**APPLICATION BY NORFOLK COUNTY COUNCIL FOR GREAT YARMOUTH
THIRD RIVER CROSSING. THE EXAMINING AUTHORITY'S SECOND WRITTEN
QUESTIONS AND REQUESTS FOR INFORMATION**

This response relates to the Examining Authority's further written questions (exQ2) dated 18 December 2019, in relation to the proposed development a river crossing. This letter contains a response to the question directed to the Environment Agency (REF 2.4.1) only.

This representation summarises the review of the revised flood models that were submitted to the Environment Agency and available to view as of 10th December 2019; and the Flood Risk Assessment (FRA) as submitted to the ExA Ref: 6.2- Environmental Statement Appendix 12B which was partially updated by the memorandum referenced GY3RC- Environment Agency Further Sensitivity Flood Modelling (additional review comments) dated 28 November 2019. The additional information submitted does not appear to be available to view on the National Infrastructure Planning Application webpage. Whilst many of the conclusions of the FRA are reasonable and adequately evidenced, there are some areas of concern that remain.

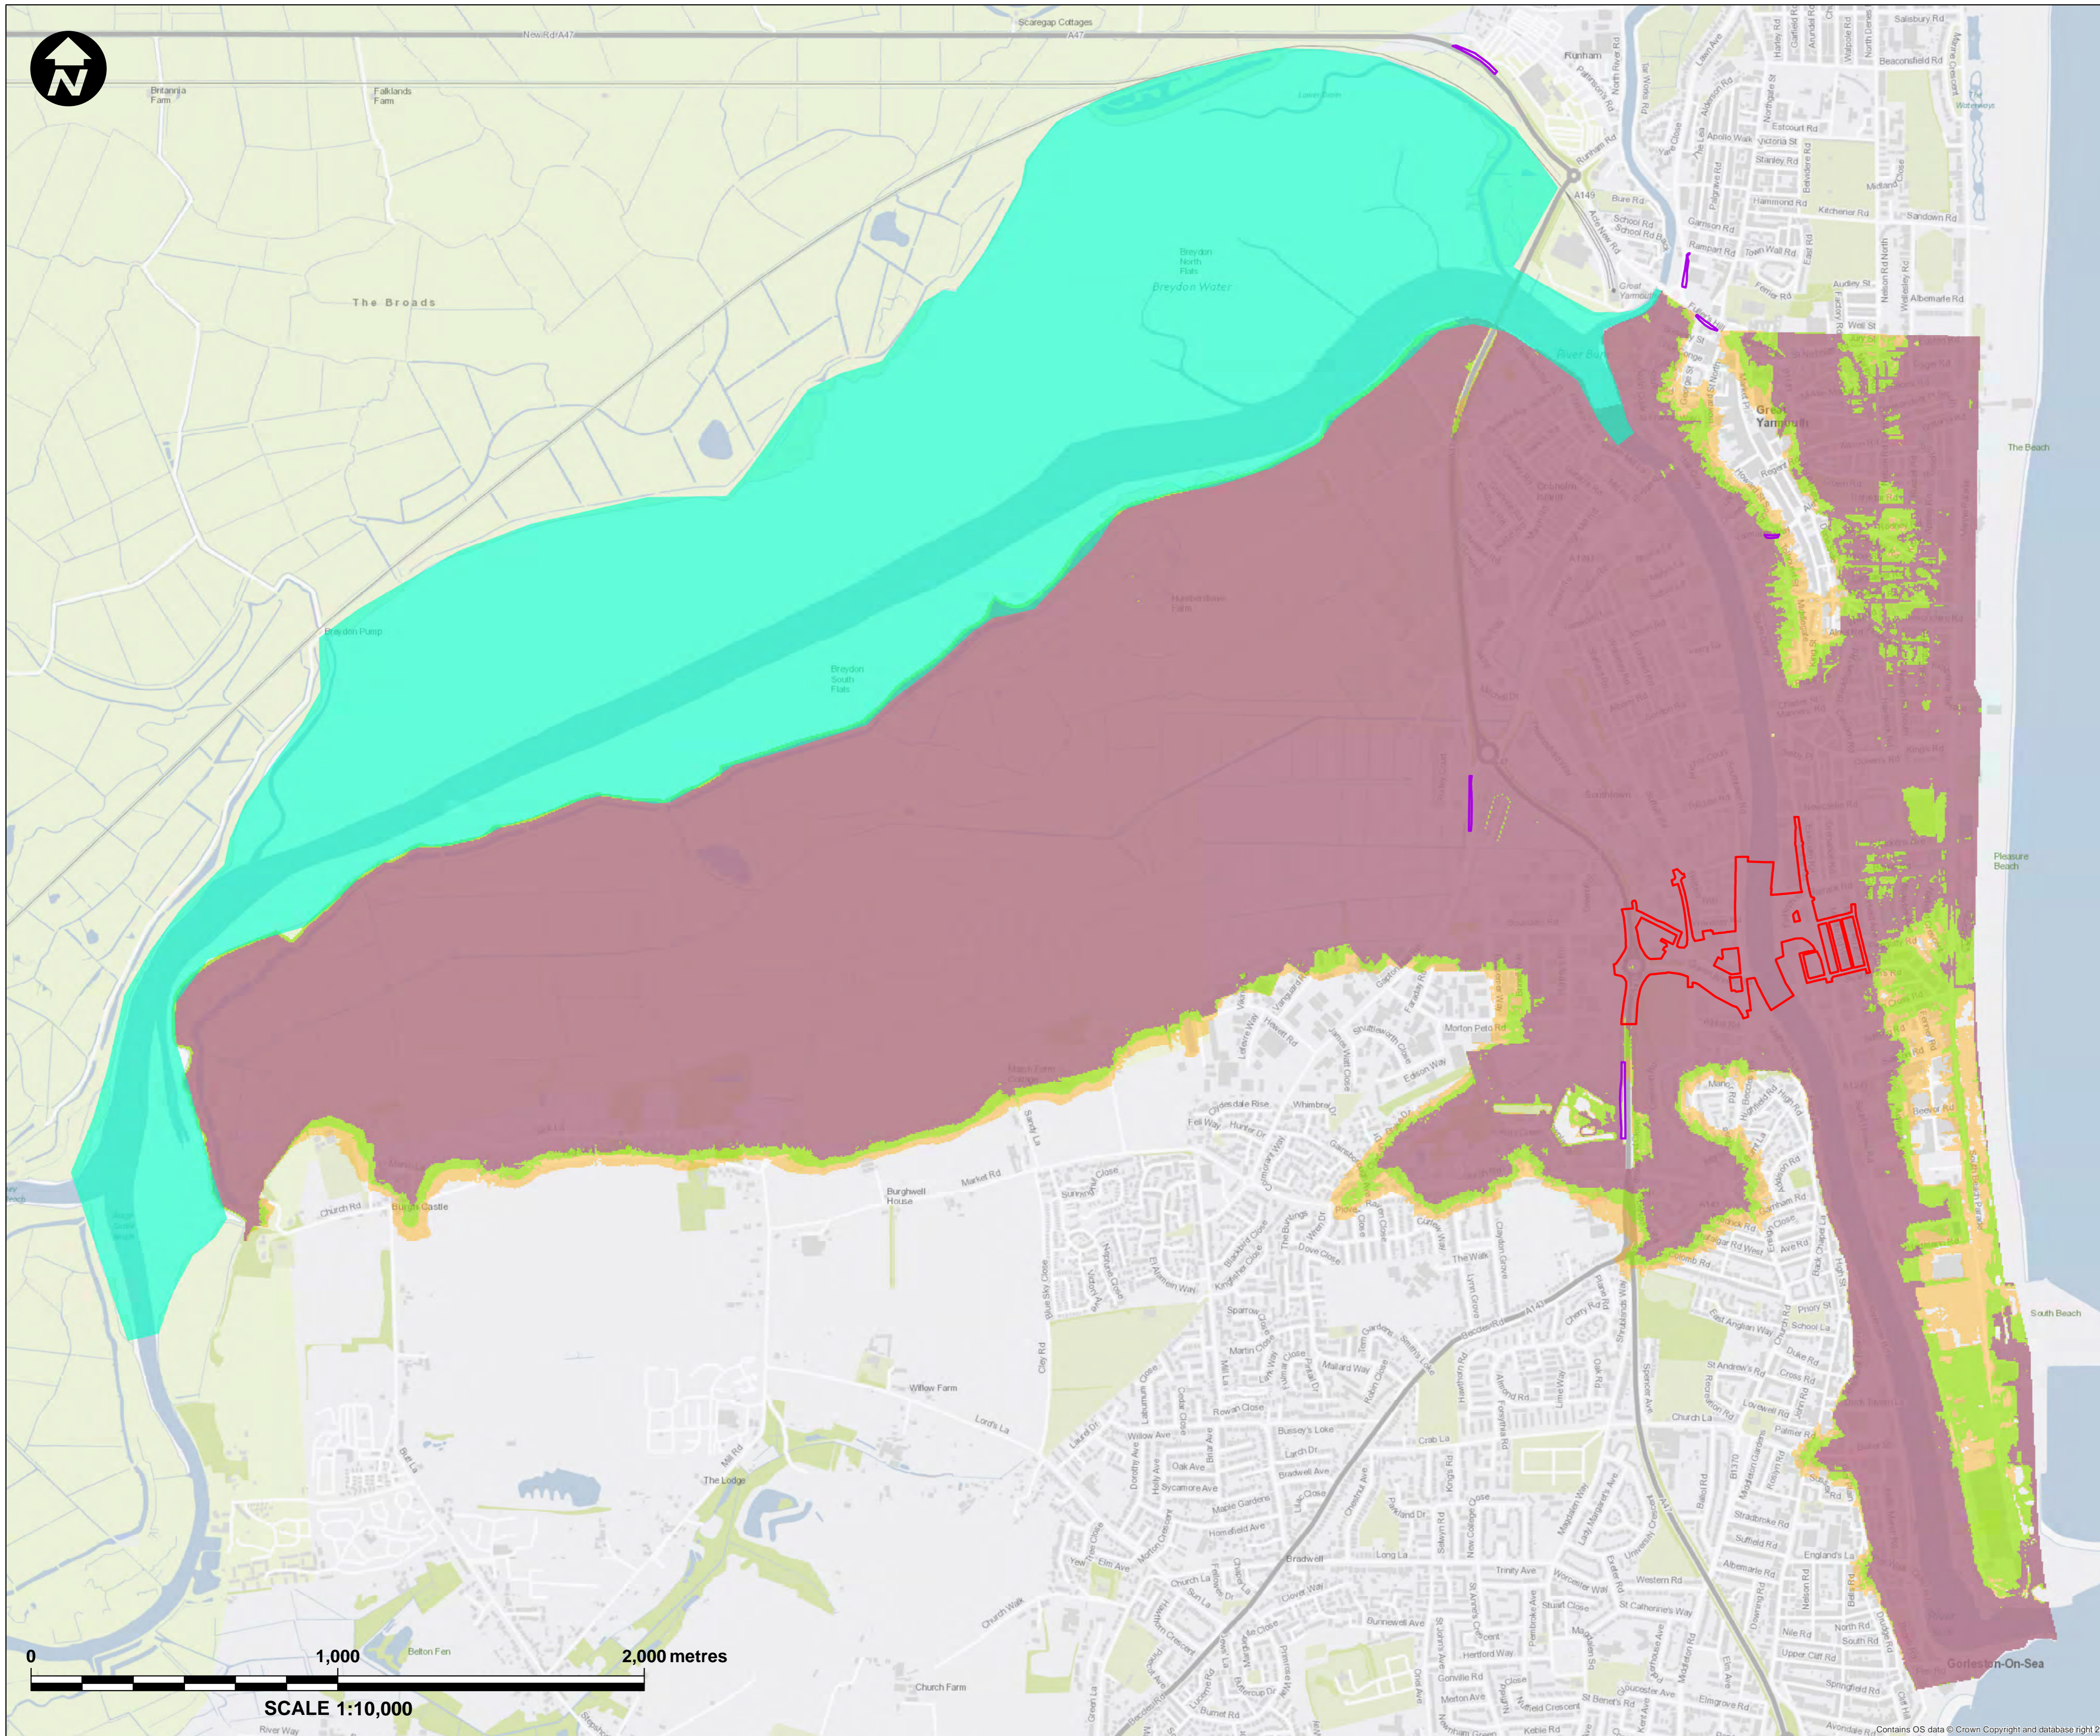
Section 6.2.45 of the FRA states that these in-channel changes for the 5% (1 in 20) AEP plus climate change event have less impact on the floodplain than the changes in the current day event. However figure 12.8 shows that the baseline 5% (1 in 20) + AEP plus climate change event is flooding the floodplain, when the current day 5% (1 in 20) AEP event shows that the floodwater remains in channel. No figure has been provided showing the change in flood level or hazard on the floodplain for the 5% (1 in 20) AEP plus climate change event, so any change in risk in the floodplain is unknown.

DRAWING NUMBER
 GYTRC-WSP-EGN-XX-DR-EN-2107

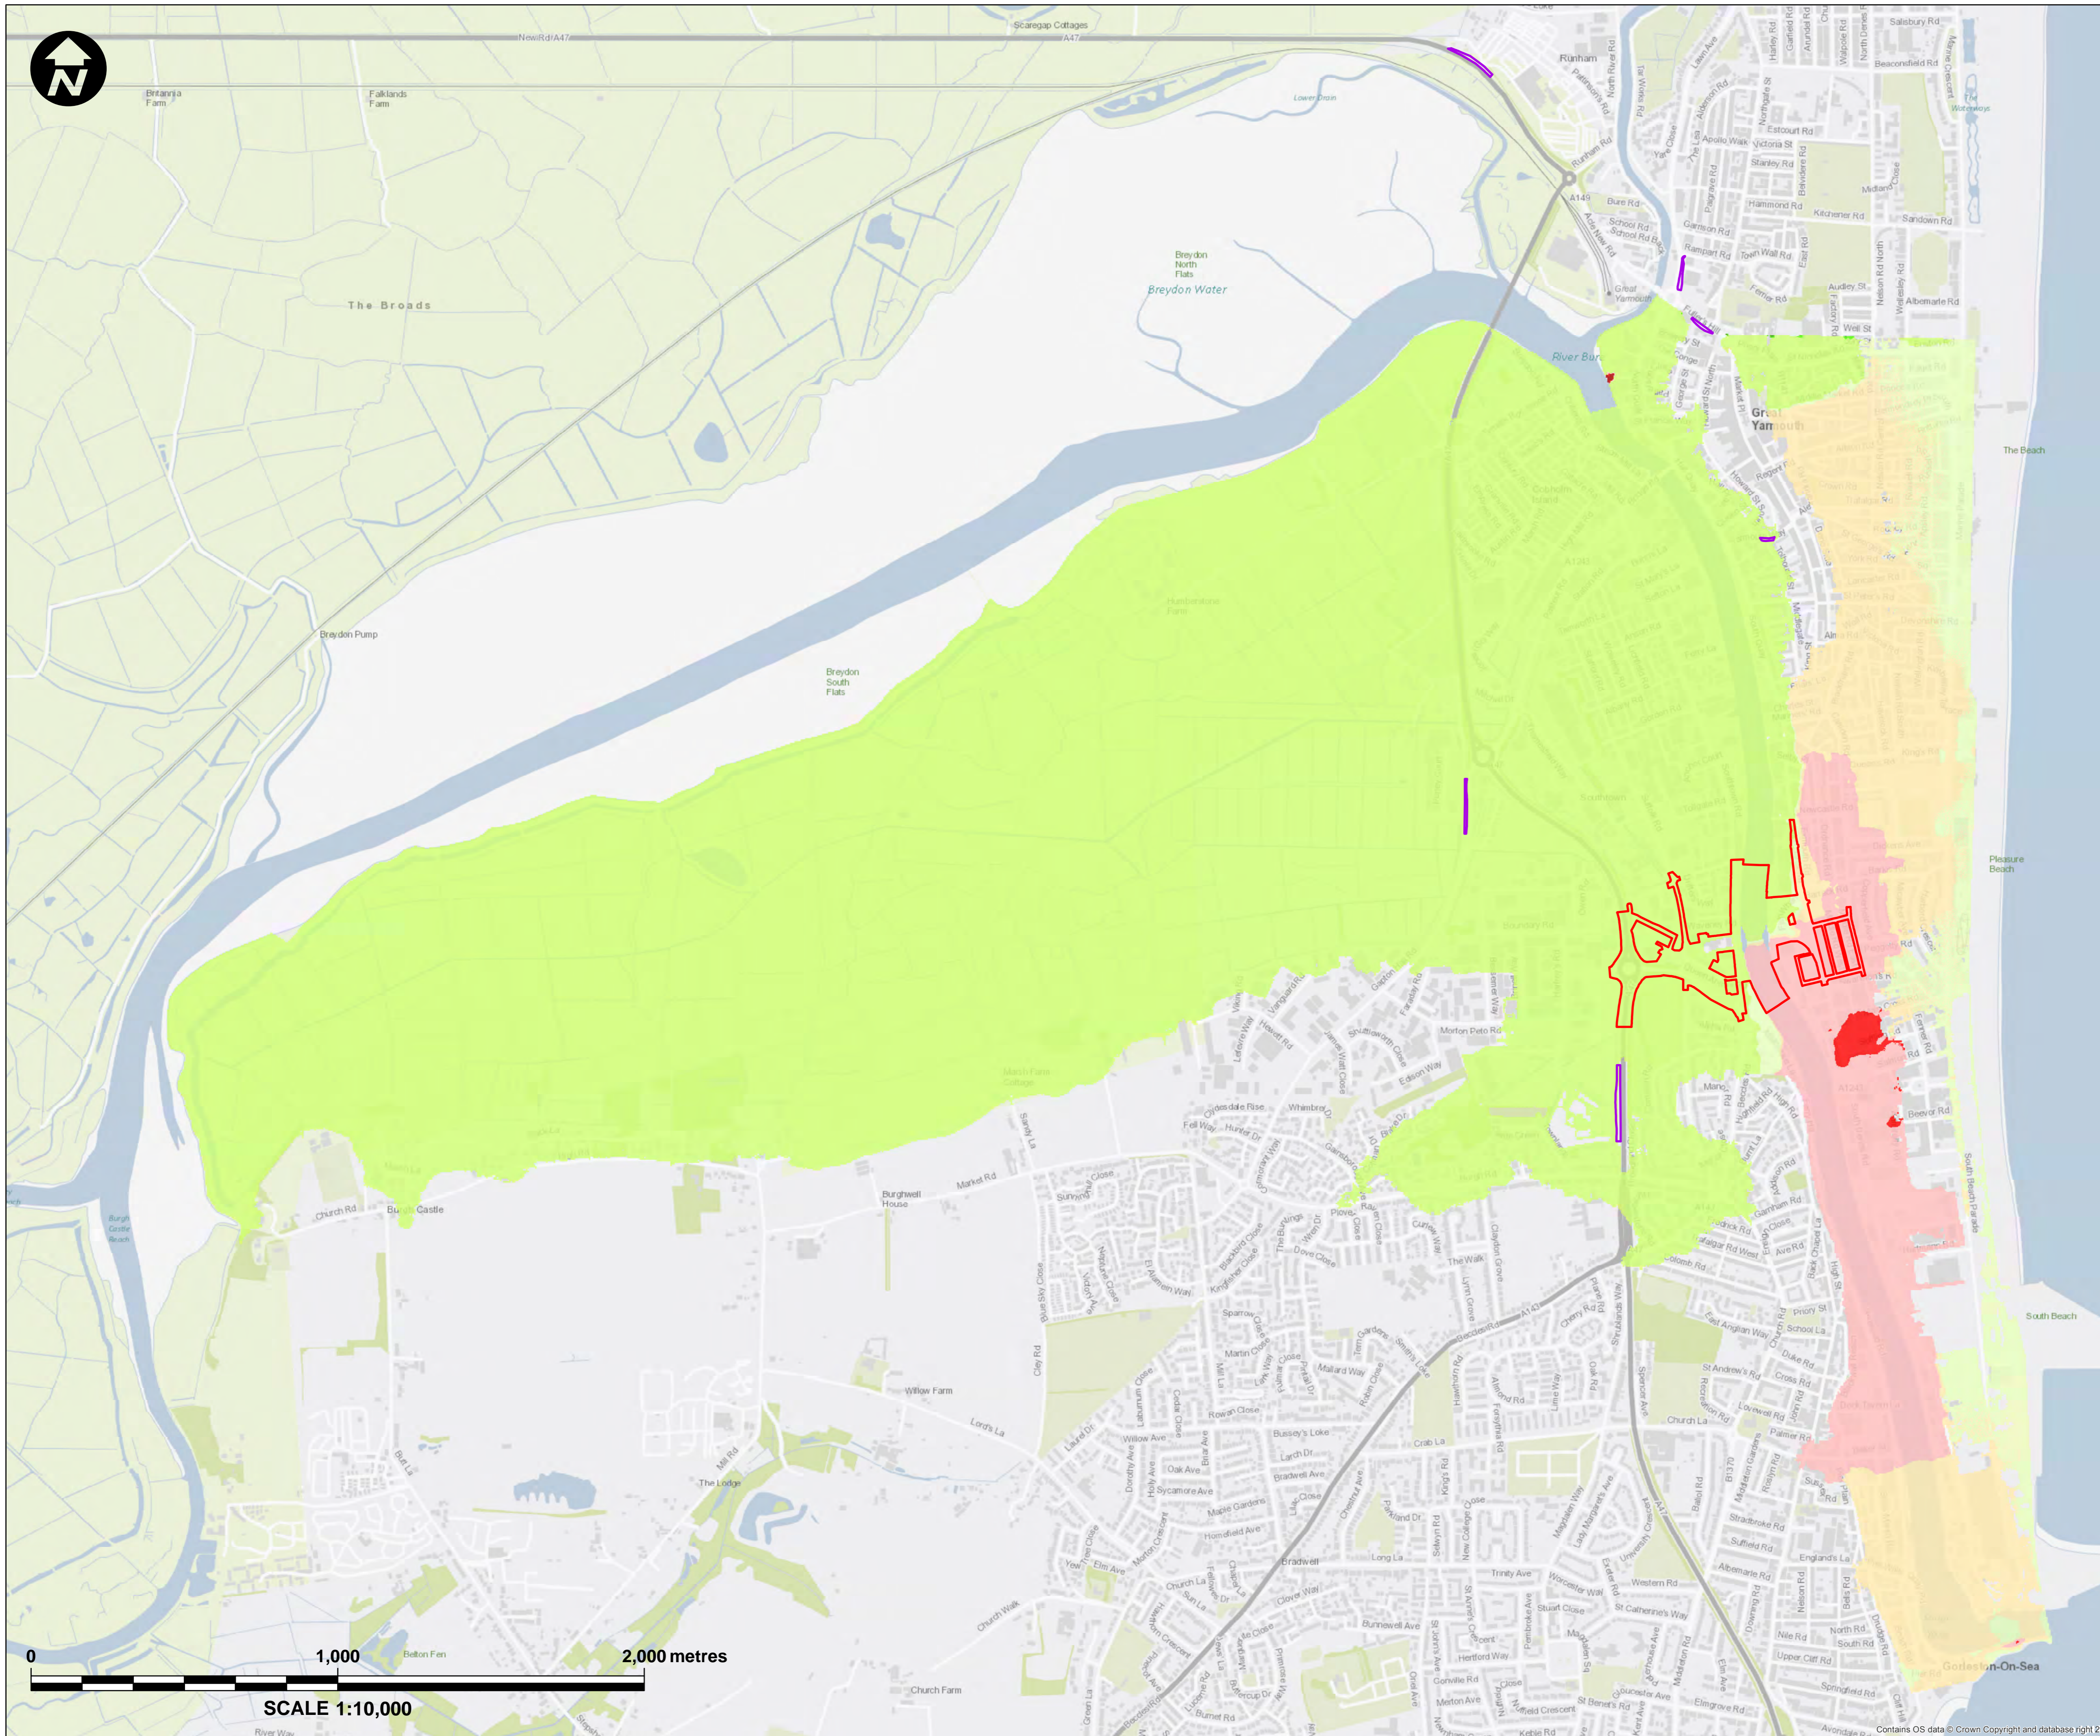
Section 6.2.45 of the FRA states that these in-channel changes for the 0.5% (1 in 200) AEP plus climate change event have less impact on the floodplain than the current day event. Figure 12.9 shows that to the south scheme there are increase in flood risk of up to 0.3 metres depth, and also shows that to the north of the scheme that there are small areas with an increase to flood risk of over 0.3 metres depth.
